**West Yorkshire Police
Kirklees District**

To: Nick Hirst	Ref: 2019/90502 Date: 13 th March 2019
----------------	--

Site Location: Land off Fernside Avenue, Almondbury, Huddersfield, HD5 8PH

Application Type: Kirklees Neighbourhood Housing dwellings

DRAWING TITLE
Proposed Sections

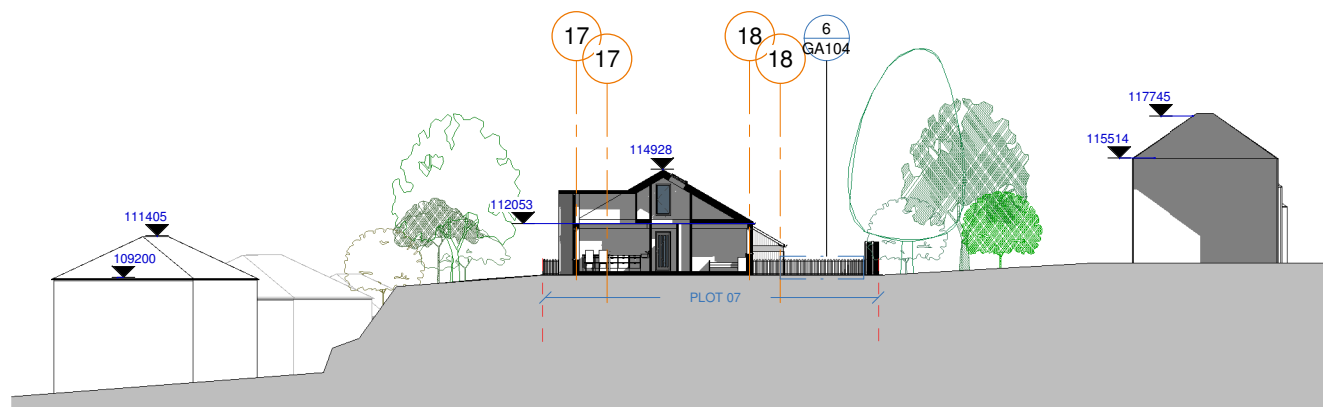
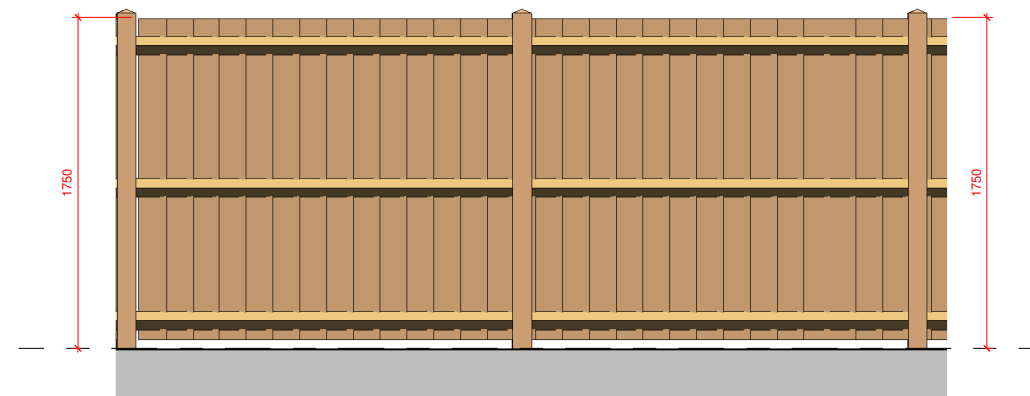
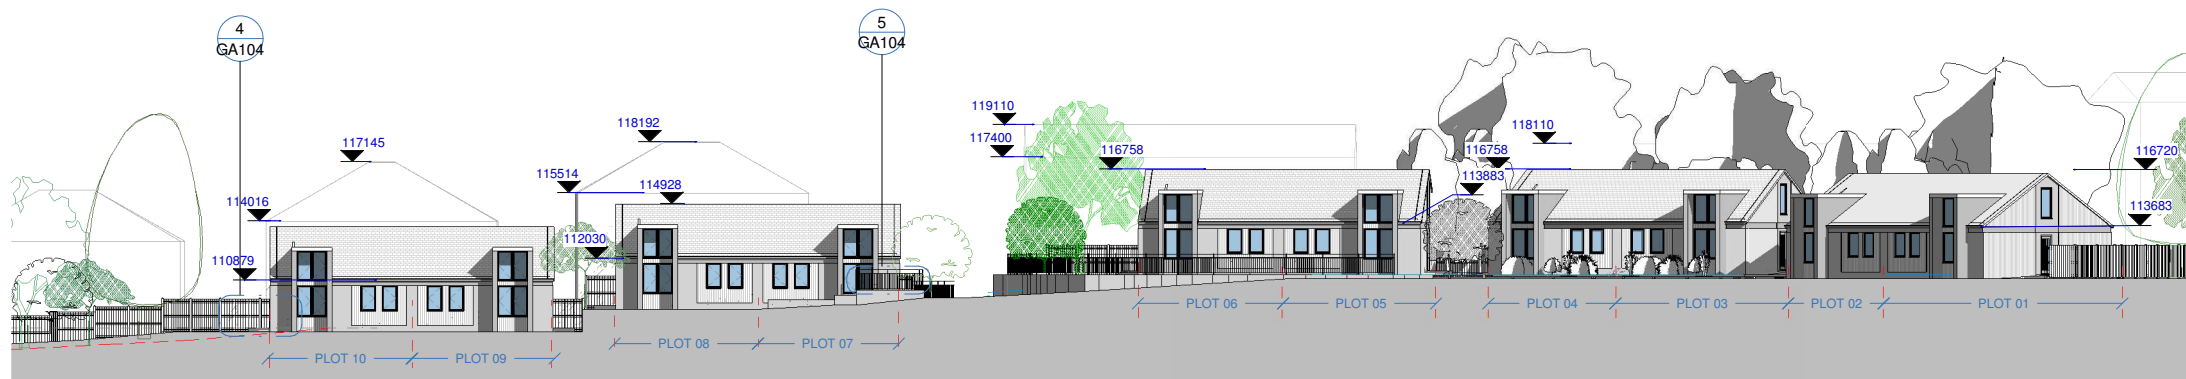
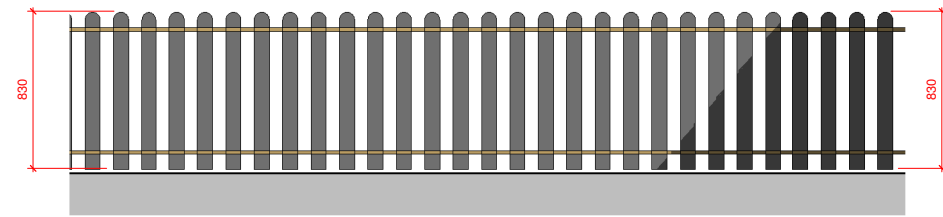
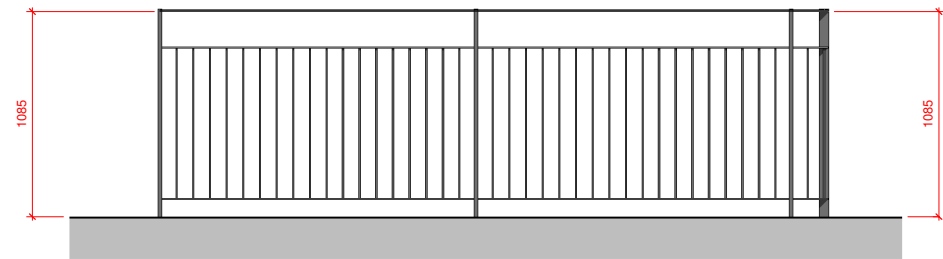
I would recommend the rear boundary treatments for each plot are to a height of 1800mm such as masonry materials, double sided close boarded timber fencing or other durable materials. Additional trellis topping fencing could be added subject to security requirements along the site perimeter.

Rear plot dividers were discussed at the meeting, it was agreed that these should be 1000mm close boarded fencing with an additional trellis topping of up to 750mm consisting of the same material as above should be installed between properties. This would reduce the effect of a solid partition fence but retain a higher level of security for each plot.
